**Our Ref: M/82/12/
Your Ref:**

Application for Planning Permission for Works or Extension to a Dwelling

Development Single storey conservatory erected to the rear elevation of property

Location 50 The Byway Middleton-on-Sea

Drawing:
Location Plan

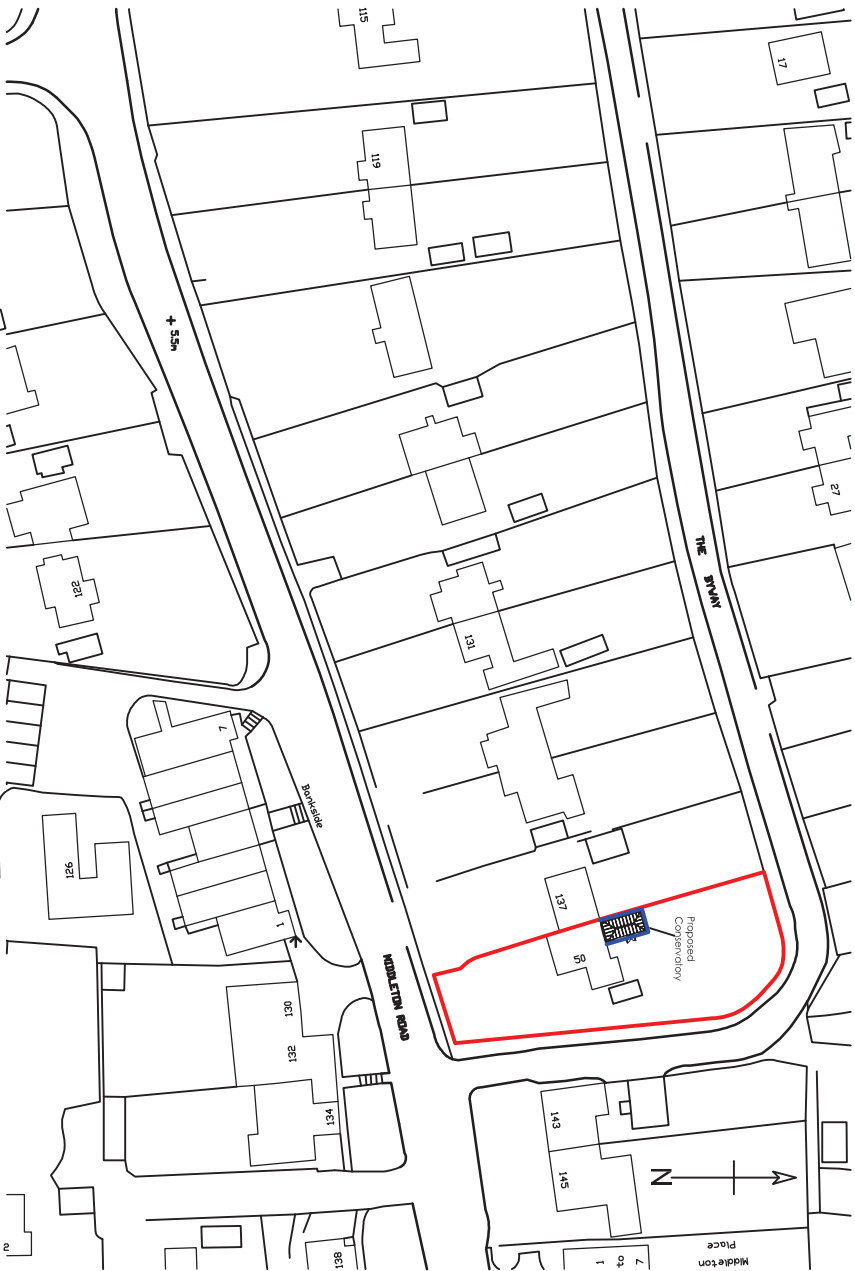
Please submit amended location and block plans to show the site area edged in red and the proposed conservatory clearly highlighted
